**re: Grading & Servicing Plan Review
Proposed Development
15 Oblats Avenue – Ottawa**

file: PG5329-MEMO.02 Revision 1

- Grading Plan – 15 Oblats Avenue, Ottawa - Project No. 221-02976-00 – Drawing No. C001 - Revision 3 dated March 27, 2023.
- Servicing Plan – 15 Oblats Avenue, Ottawa - Project No. 221-02976-00 – Drawing No. C002 - Revision 3 dated March 27, 2023.

221-02976-00	
DRAWN BY: JT	
DESIGNED BY: VT	
CHECKED BY: DY	C001

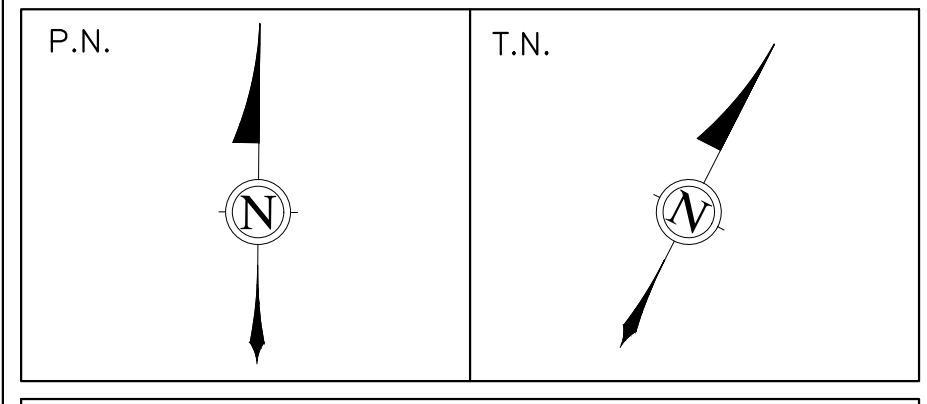
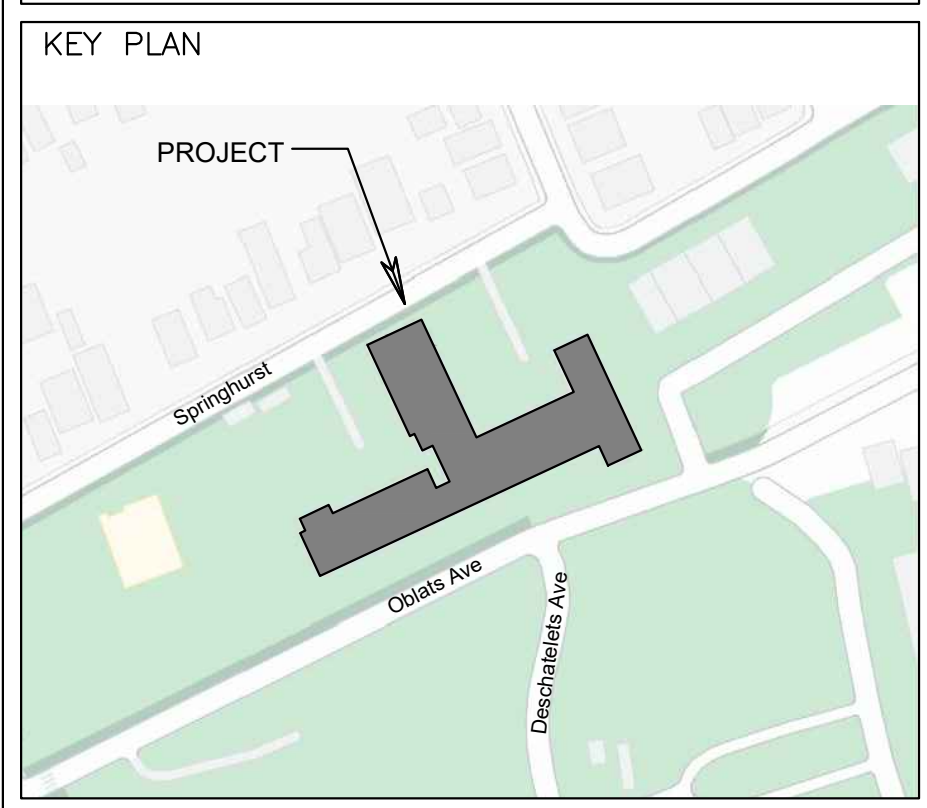
Based on our review of the above-noted grading plan drawing, the proposed grade raises at the subject site are within the recommended permissible grade raise of 1.0 m. Therefore, the proposed grading is acceptable, from a geotechnical perspective.
